LINCOLNSHIRE COUNTY COUNCIL'S RESPONSE TO CONSULTATION ON THE FOLLOWING DEVELOPMENT PROPOSAL

Application number: H16-0767-23

Proposal: Demolition of vacant former public house and erection of 88 bed care home including onsite parking amenity space and associated works.

Location: Former Bull and Monkie, Church Gate, Spalding, PE11 2RA

Drawing Title:
EXISTING FOUL & SURFACE WATER DRAINAGE
ROUTE BEYOND EXTENT OF SITE BOUNDARY

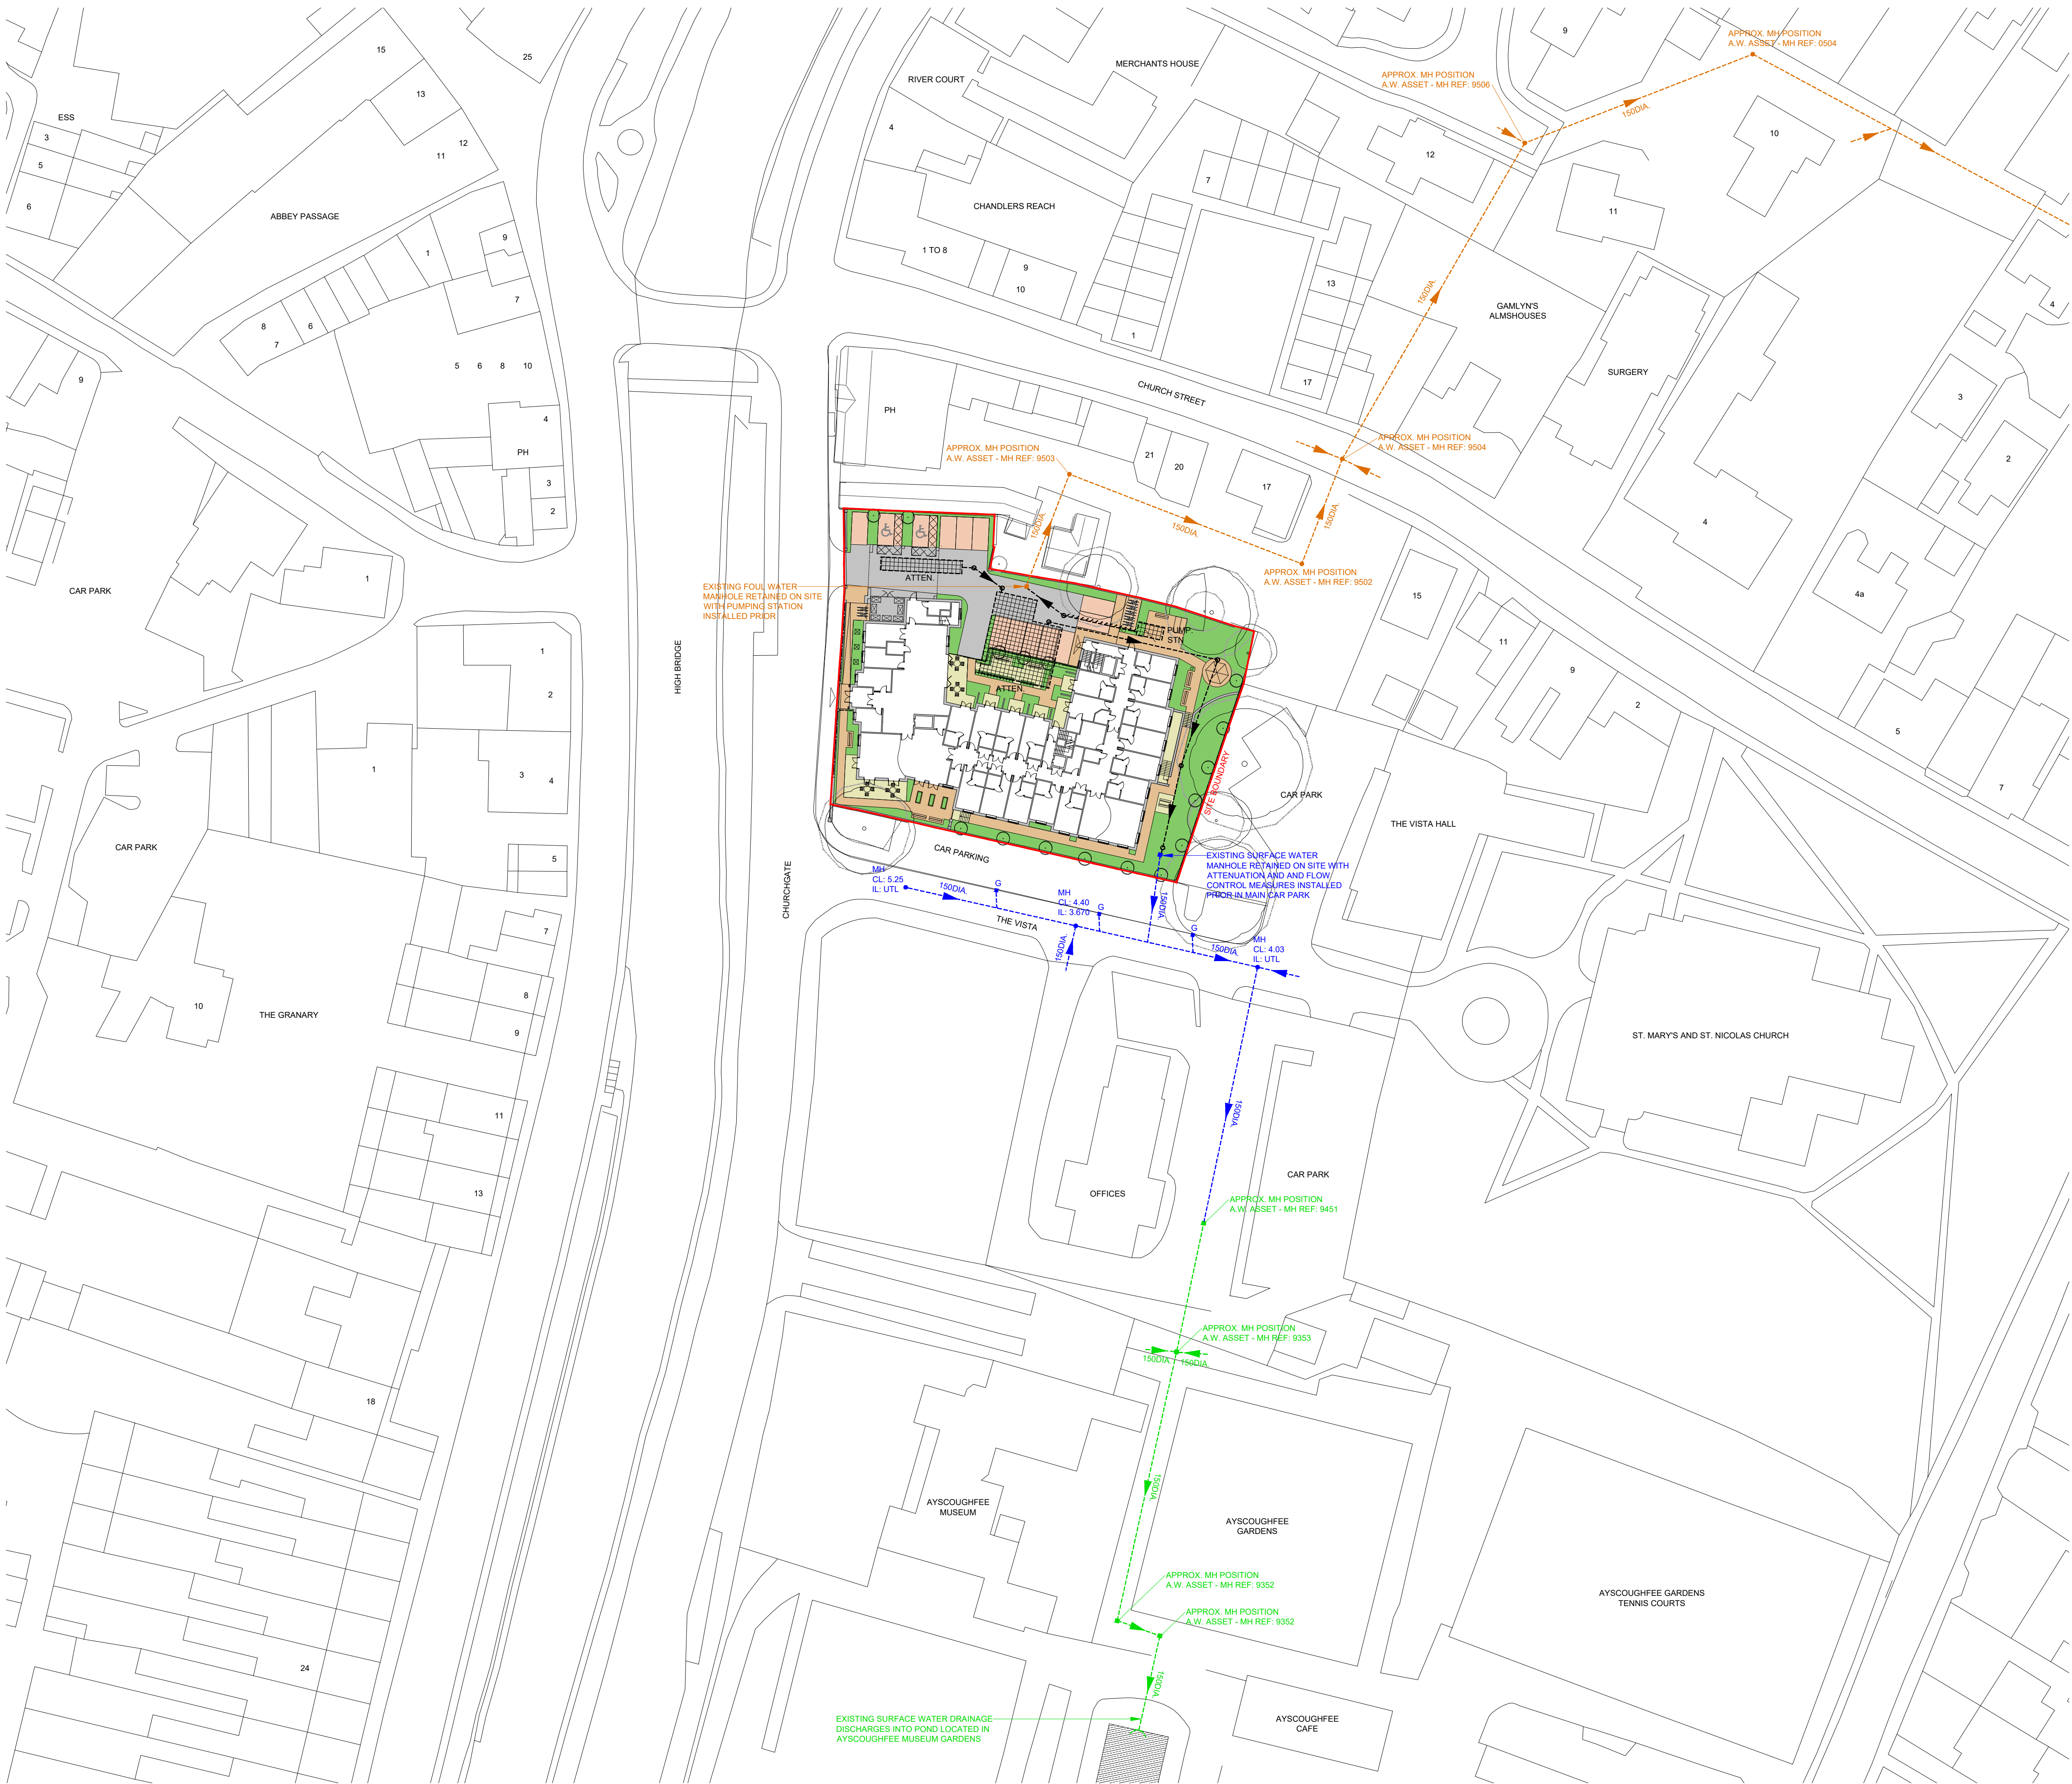
The proposed surface water drainage strategy for the development is to discharge surface water run-off into an existing surface water sewer. Whilst this option is lower down the sustainable drainage hierarchy than is ideal, the ground conditions in this area are not conducive to infiltration and there is no existing, adjoining watercourse into which surface water could be discharged. The drainage strategy does however include permeable paving where it is possible to do so and the rate of discharge is to be restricted by means of a hydro-brake or similar device with attenuated storm water being stored on the site in underground tanks. This arrangement therefore represents betterment over the historic drainage system of the Public House and makes a positive reduction in surface water flood risk to the development and to neighbouring property.
